Our Ref: BR/259/19/PD
Your Ref:

Development Notification for Prior Approval under Schedule 2, Part 3, Class O for a proposed change of use from office use (B1(a)) into 2 No. flats (C3 Dwellinghouse).
Location 20 Sudley Road Bognor Regis

Drawing Number 2019/134 Sheet 1 of 1

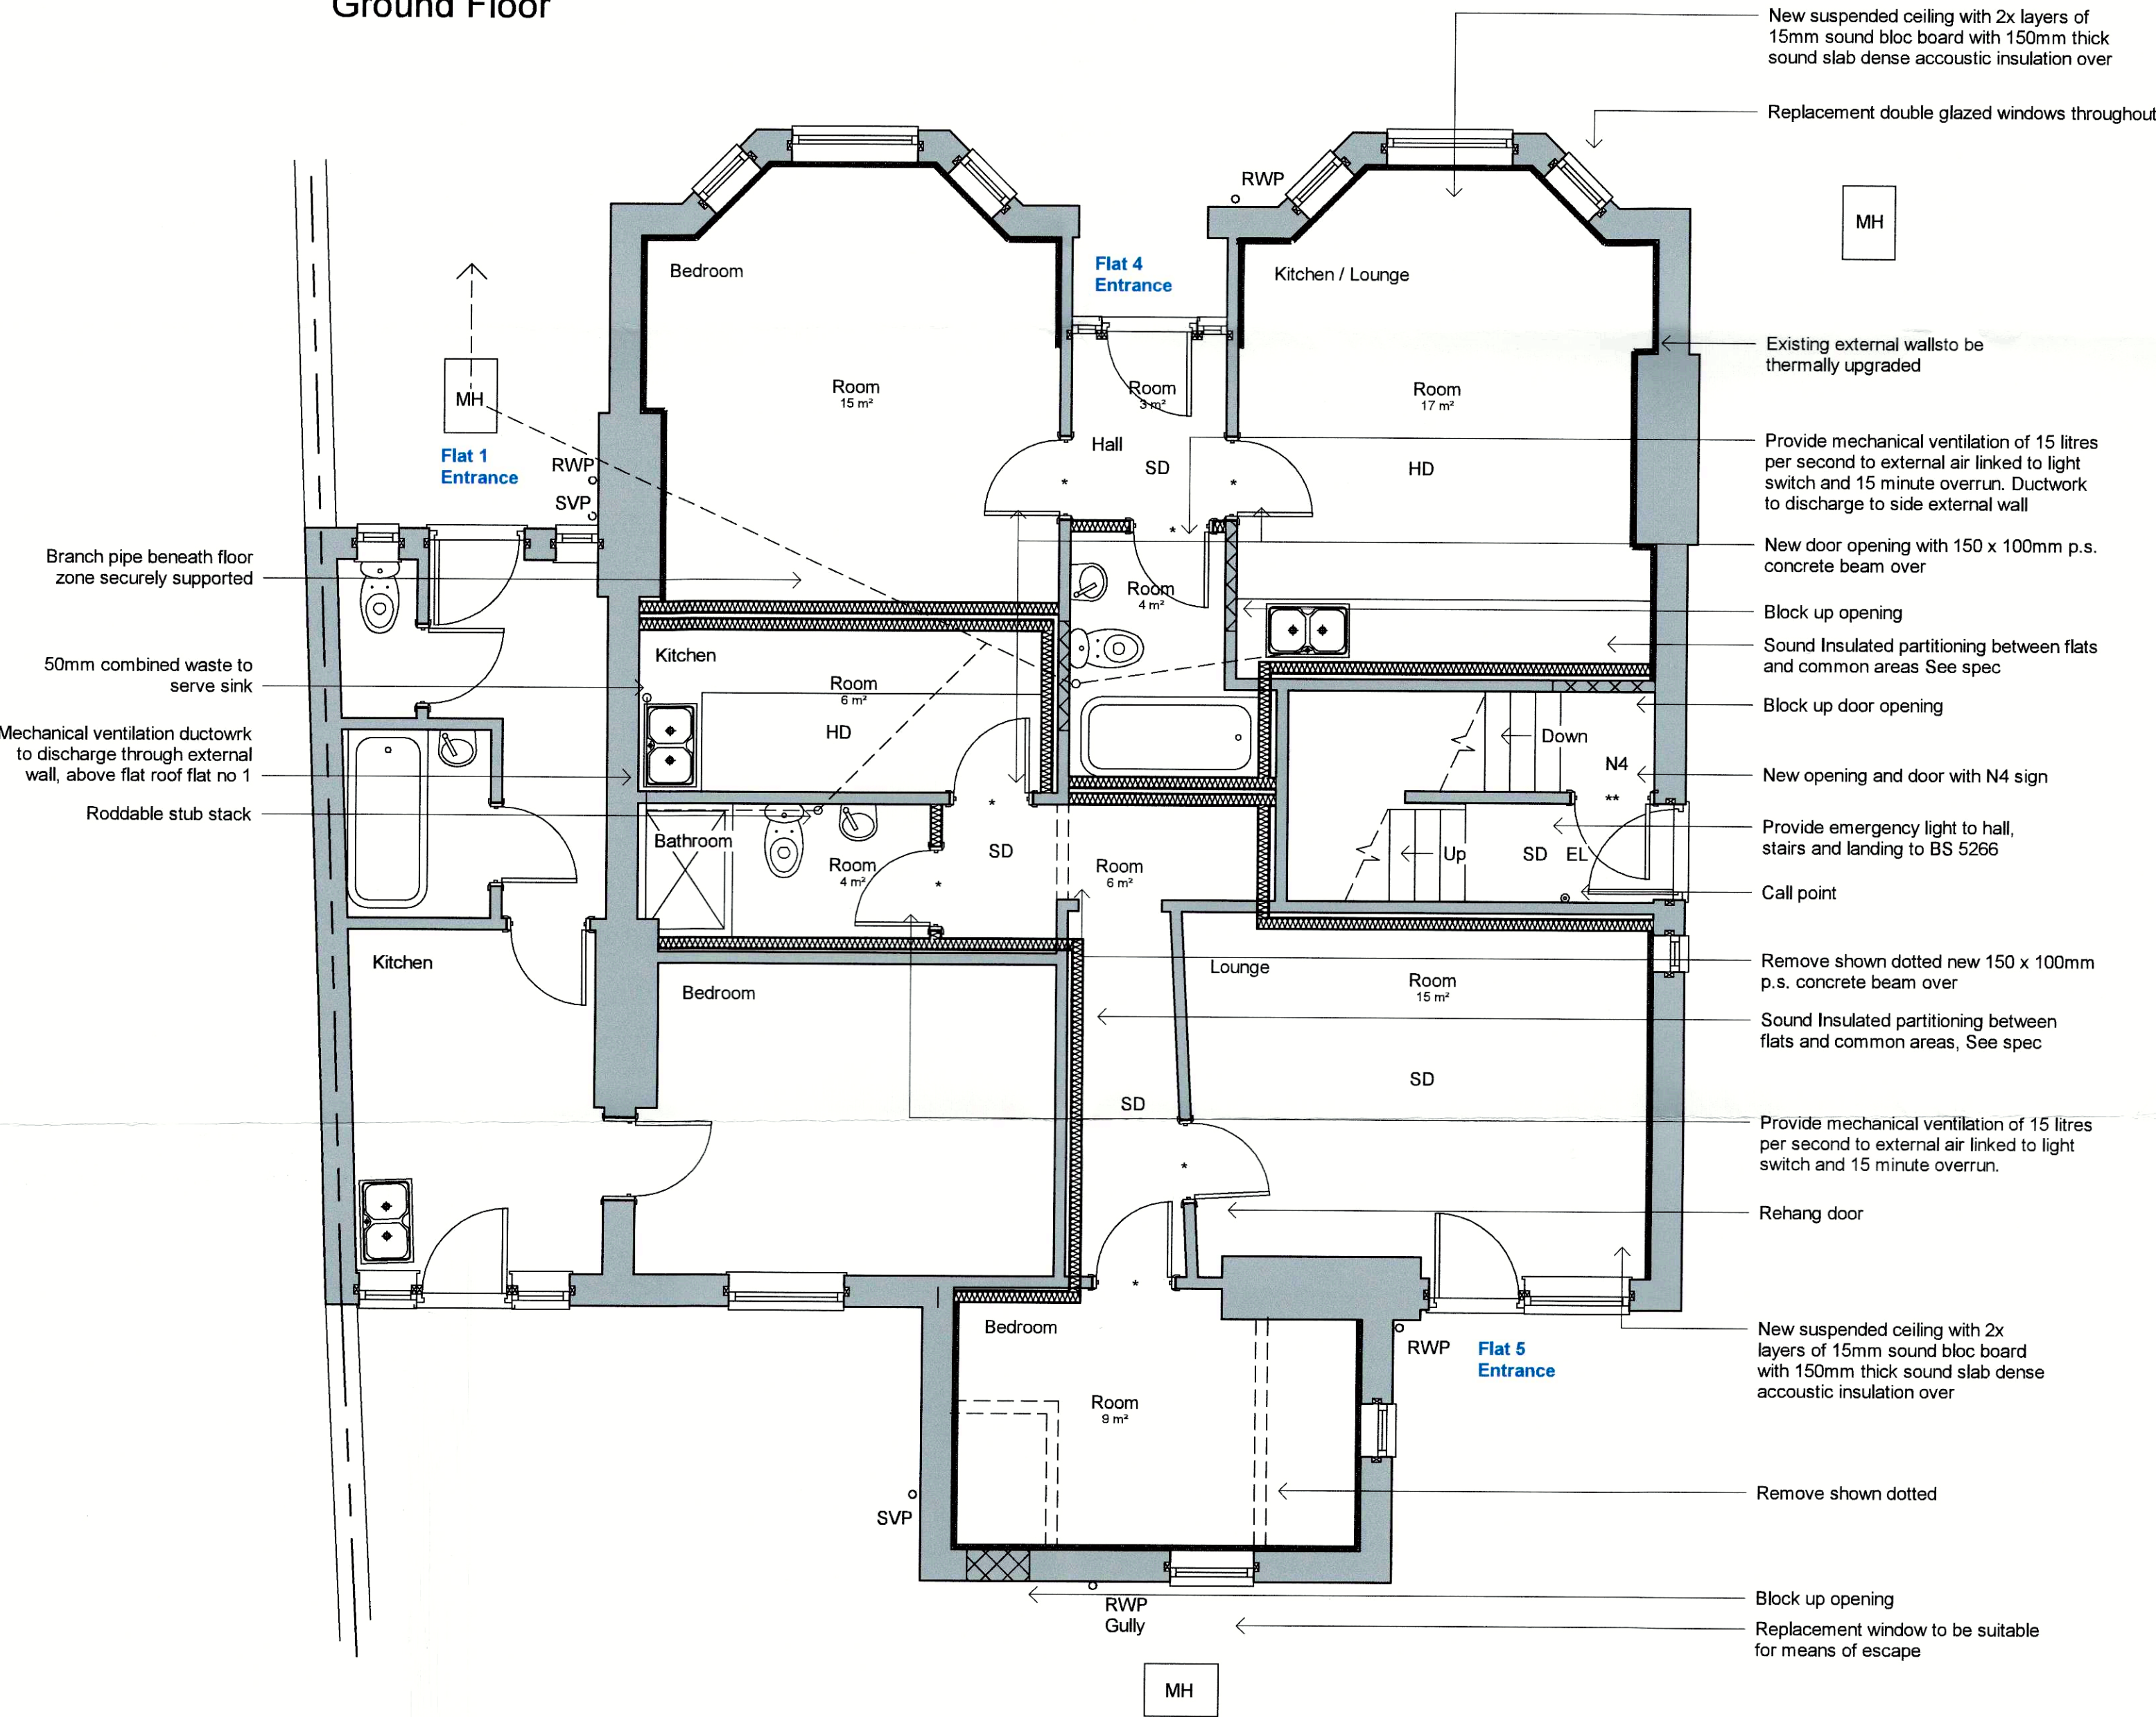
The floor plan submitted was presented on A3 sized paper whilst the legend indicates A1 sized paper. Please provide the correct sized paper for the floor plans.
